DRB Comments

RE: Lots C and E, Cagua Addition

DRB CASE NO/PROJECT NO: 1007746

Final Plat
Preliminary Plat

PLAT OF
LOTS C-1 AND E-1
CAGUA ADDITION
 ALBUQUERQUE, BERNALILLO COUNTY, NEW MEXICO
 OCTOBER, 2009

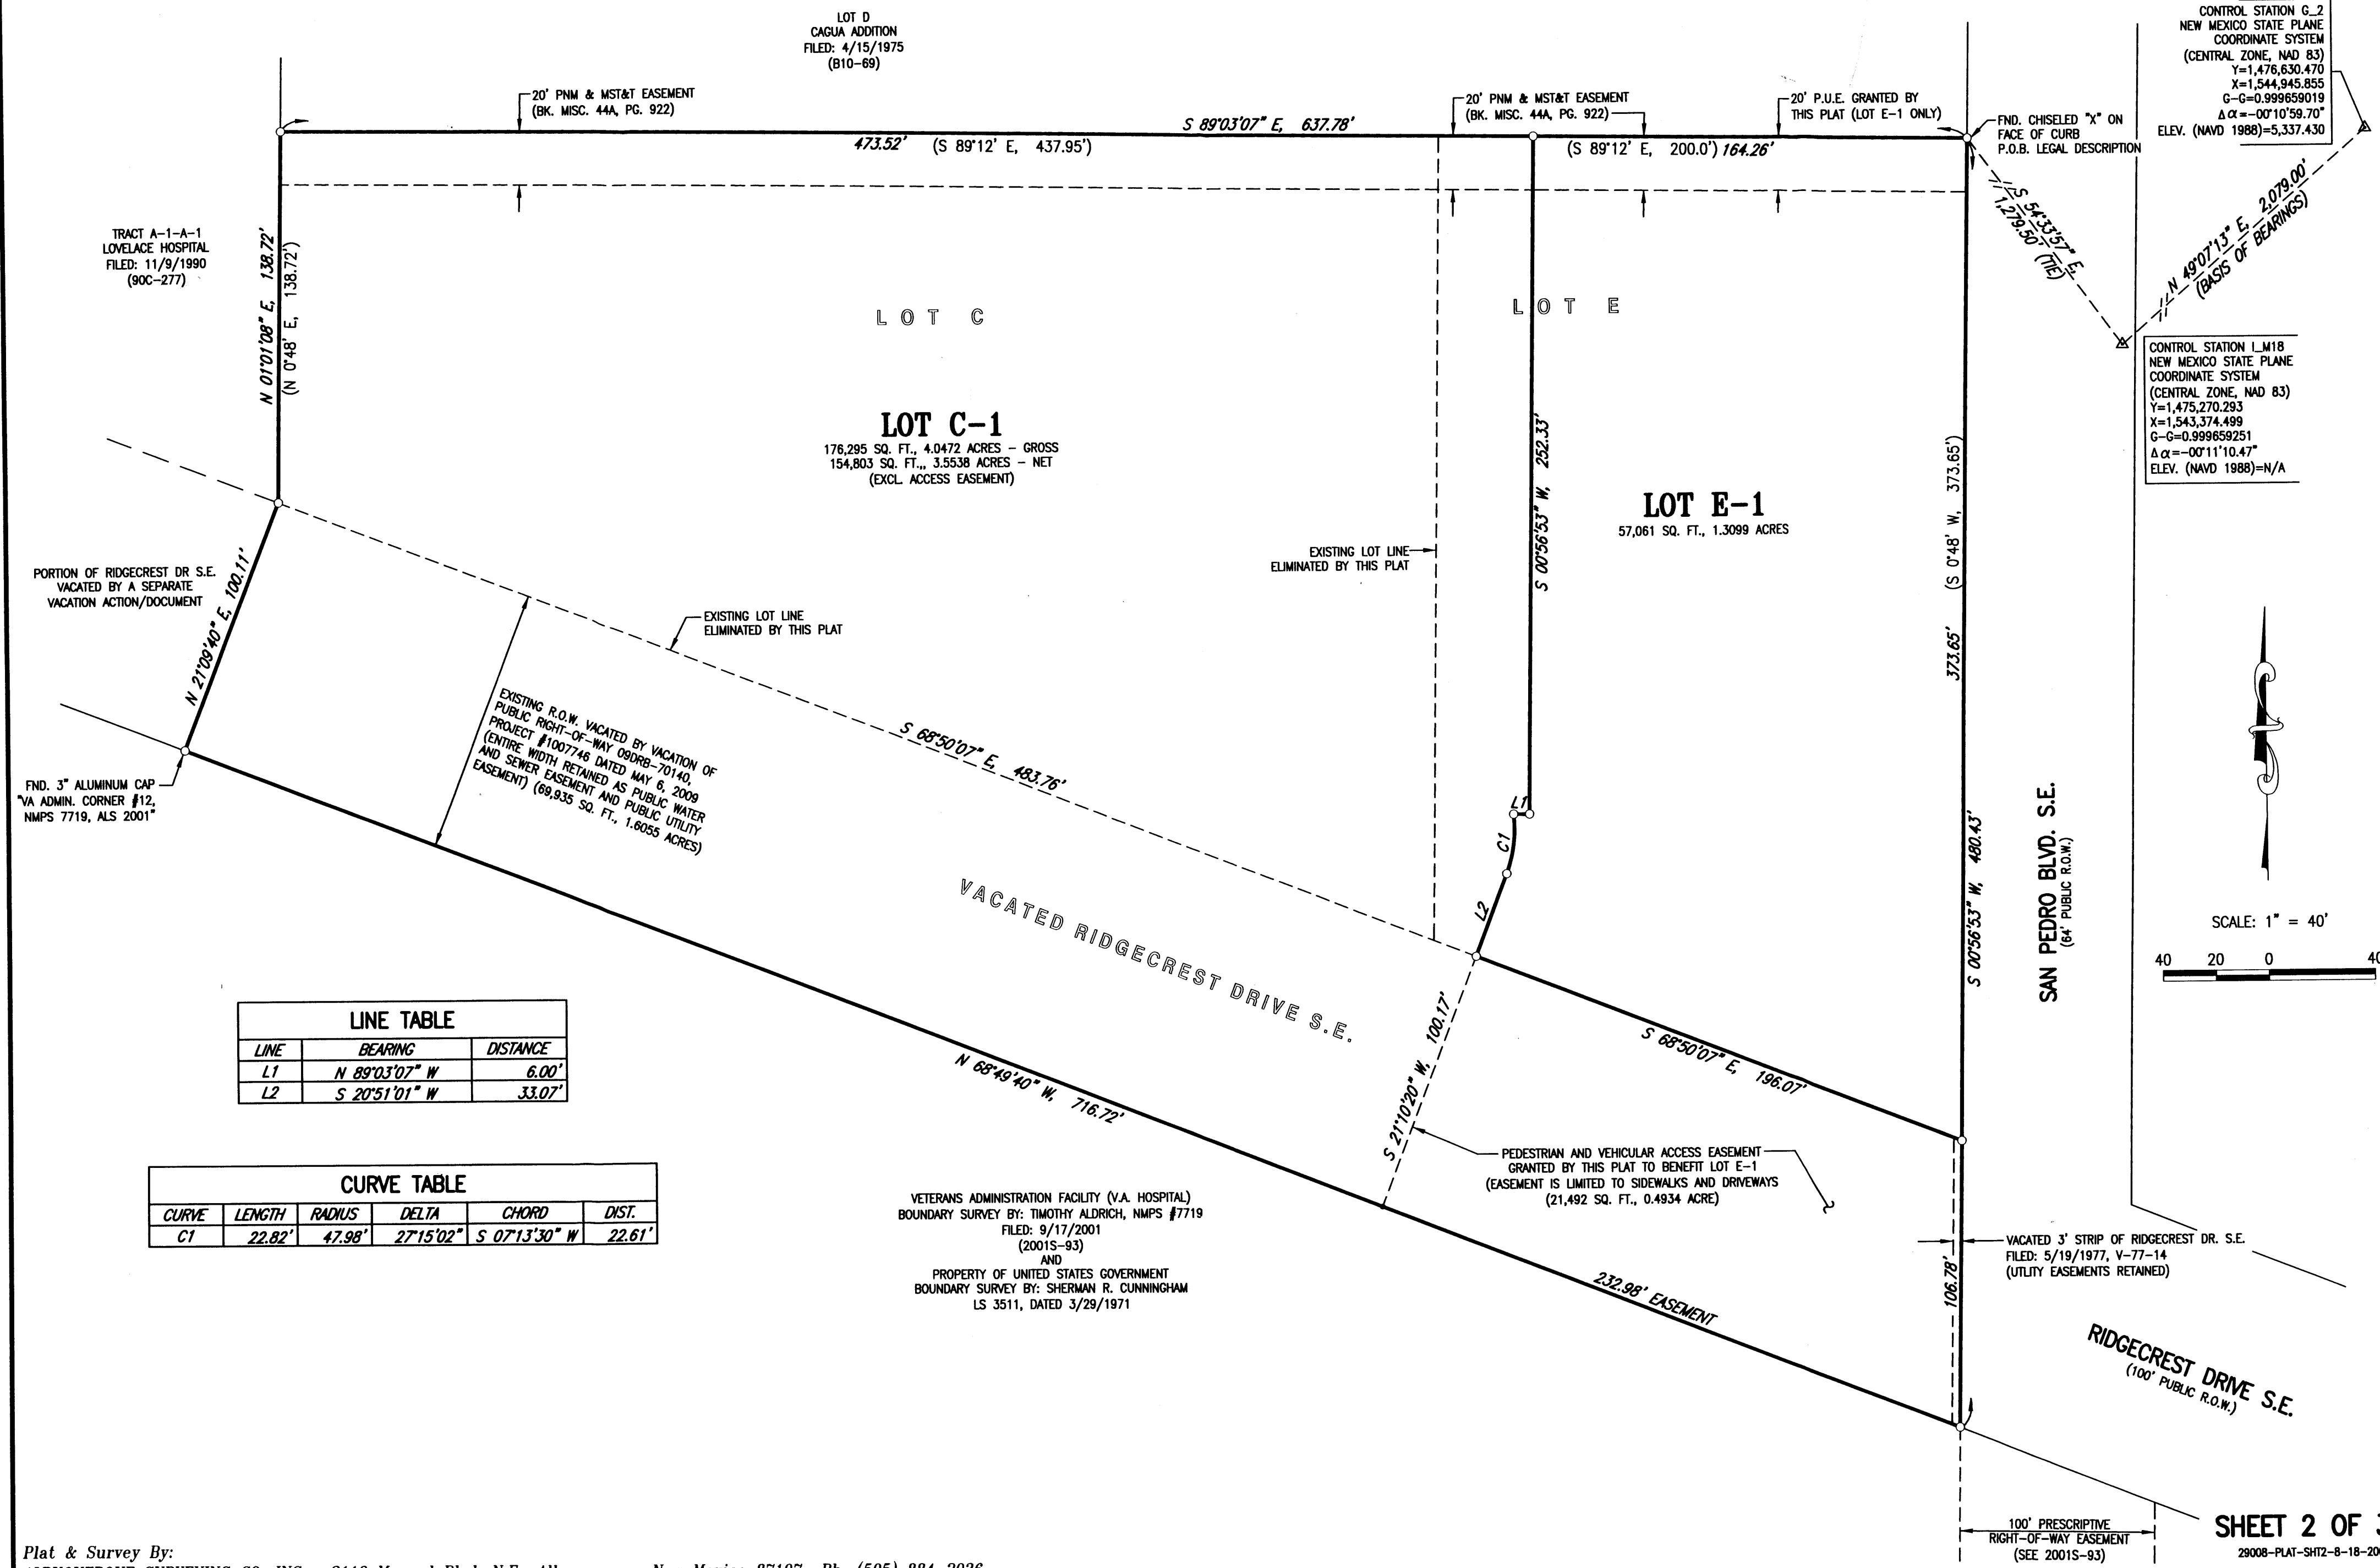
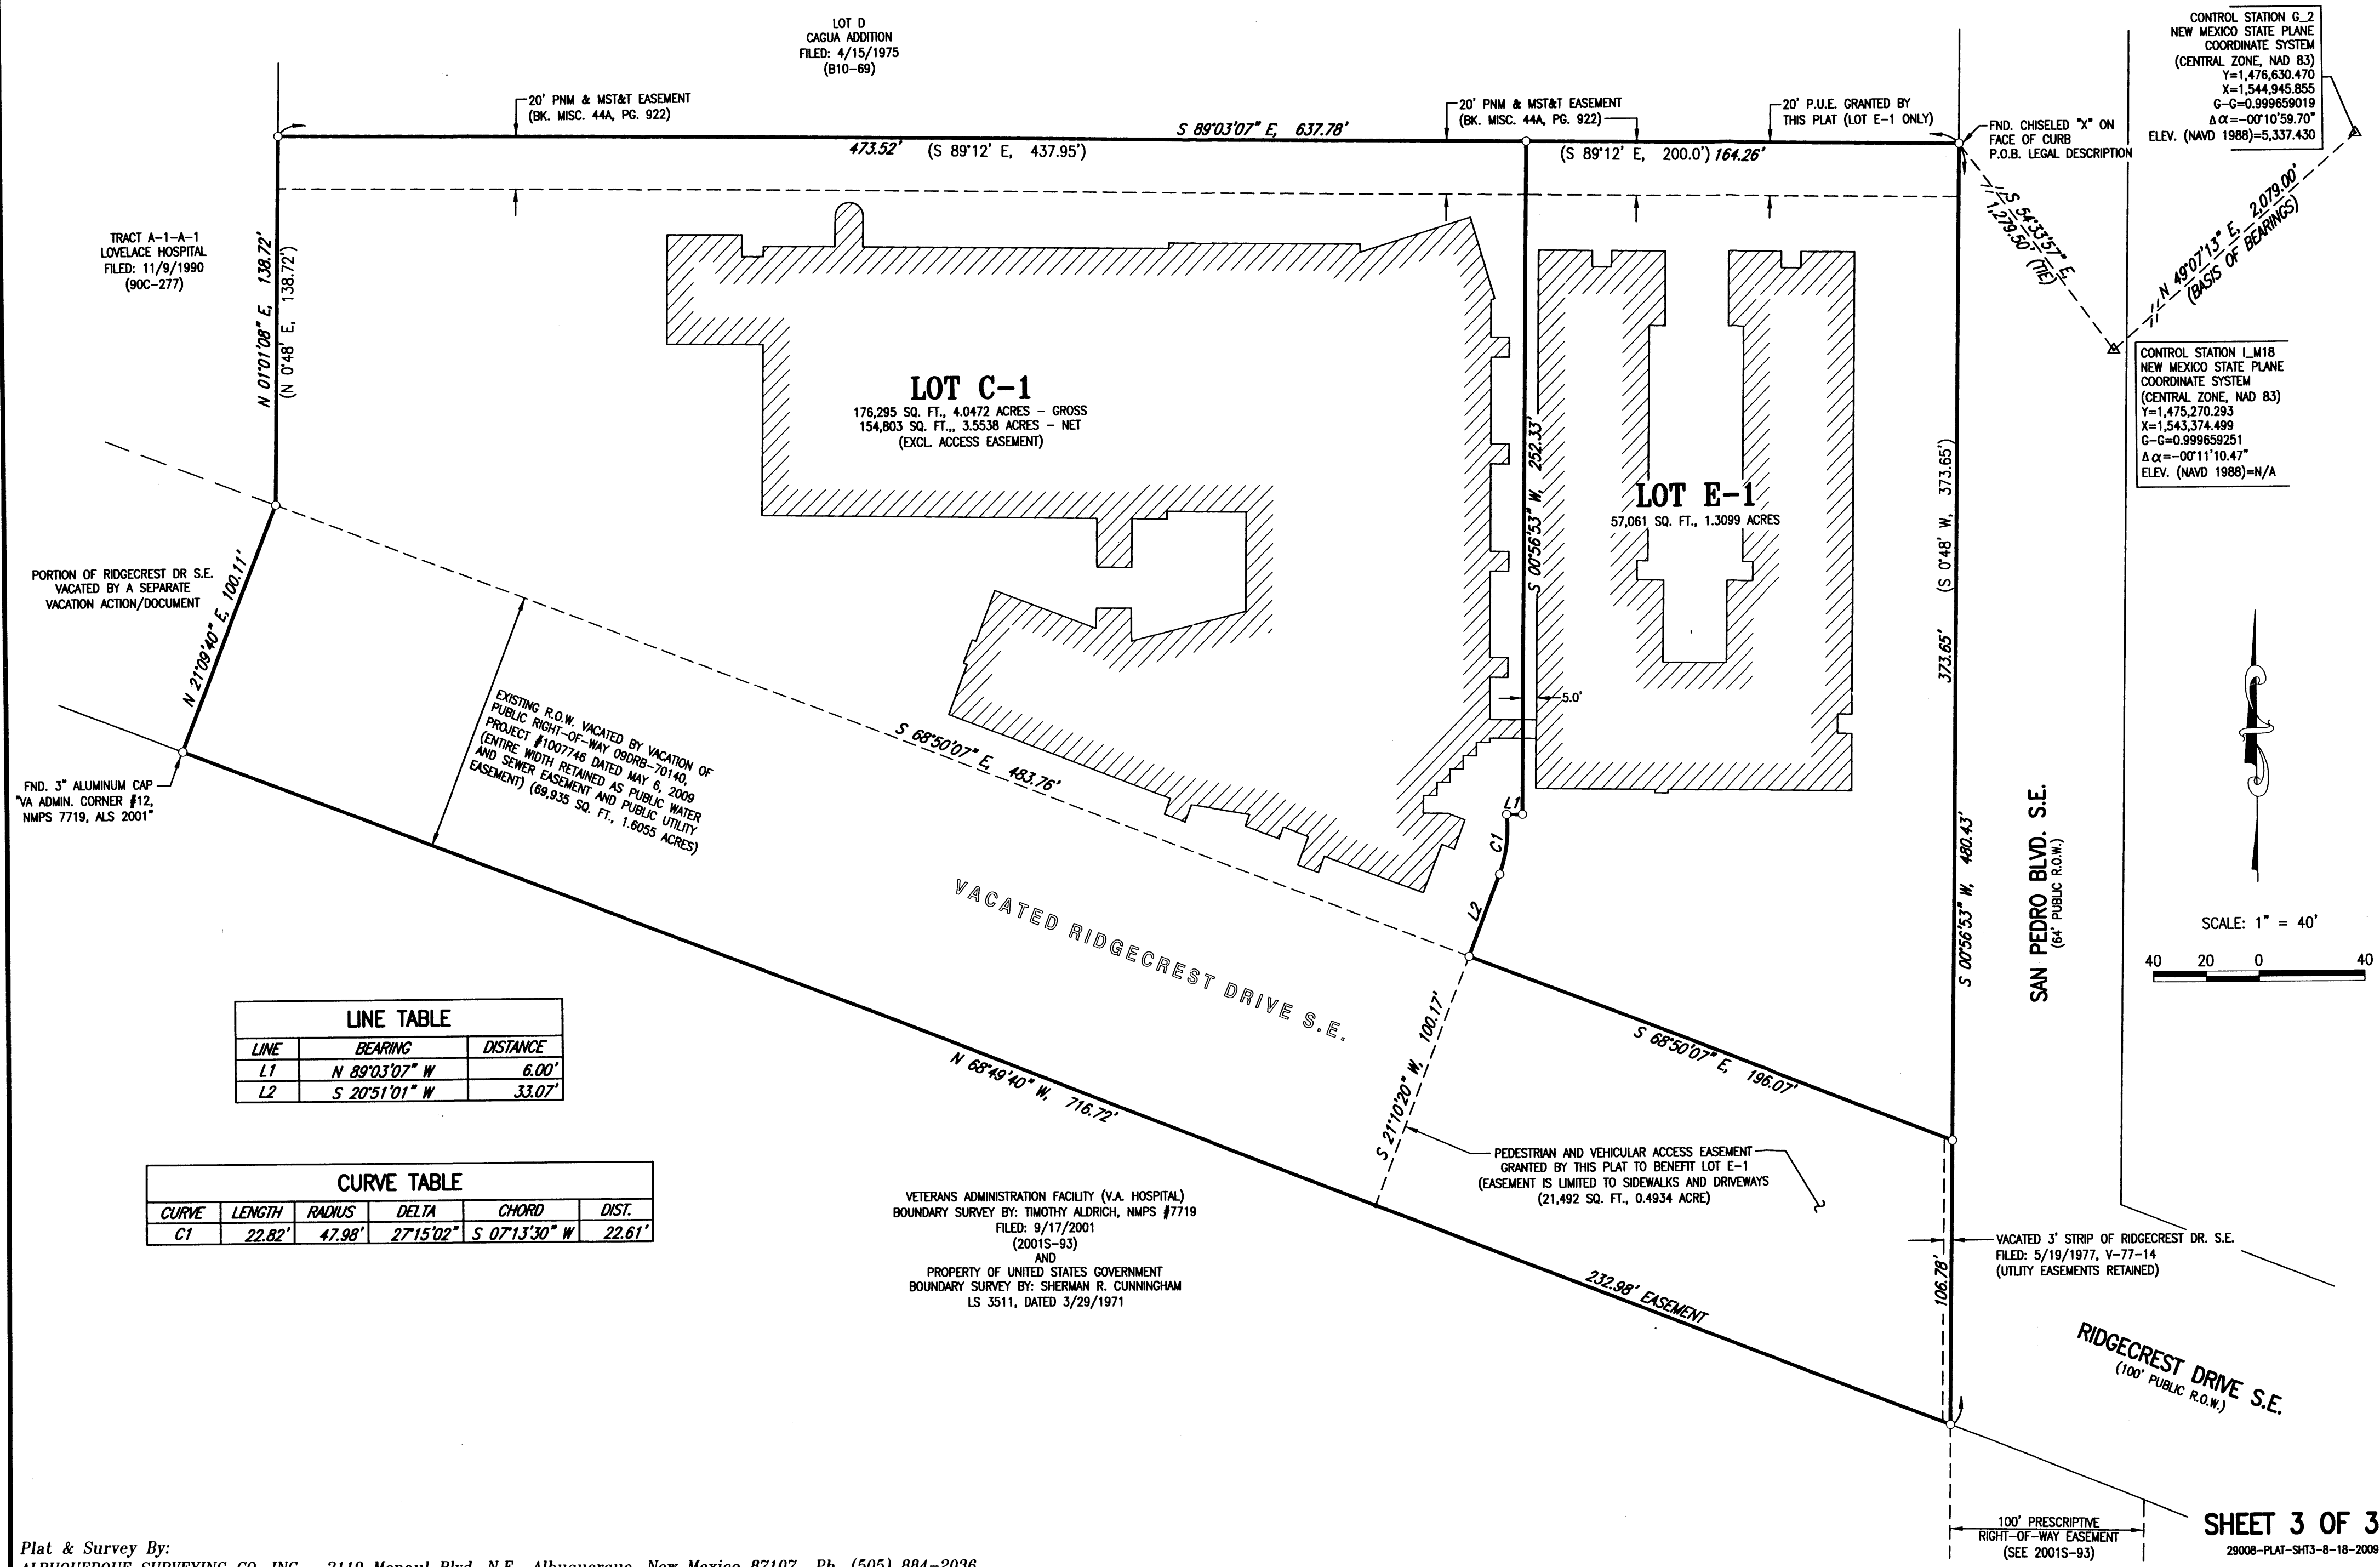
A site plan with parking calculations is needed to demonstrate that required on-site parking per the Zoning Code is met on-site (on each lot). An engineer or architect will have to certify that the building connection complies with the Building Code at the dividing property line.

Please remove zoning note (8.) from Final Plat. A Solar Note consistent with § 14-14-4-7 is required, specific to this type of request, i.e. use the words "THIS PLAT" (rather than the words "REQUESTED FINAL ACTION") at the beginning of the note, and do not use the words "OR SITE DEVELOPMENT PLAN FOR SUBDIVISION" at the end of the note.

Provision is needed for utility companies to sign the plat. AGIS Division must accept the .dxf file for this plat. Planning must record this plat to complete the vacation action.

Need owners of lots C and E to sign, not Lovelace.
Dry Utilities need to sign.
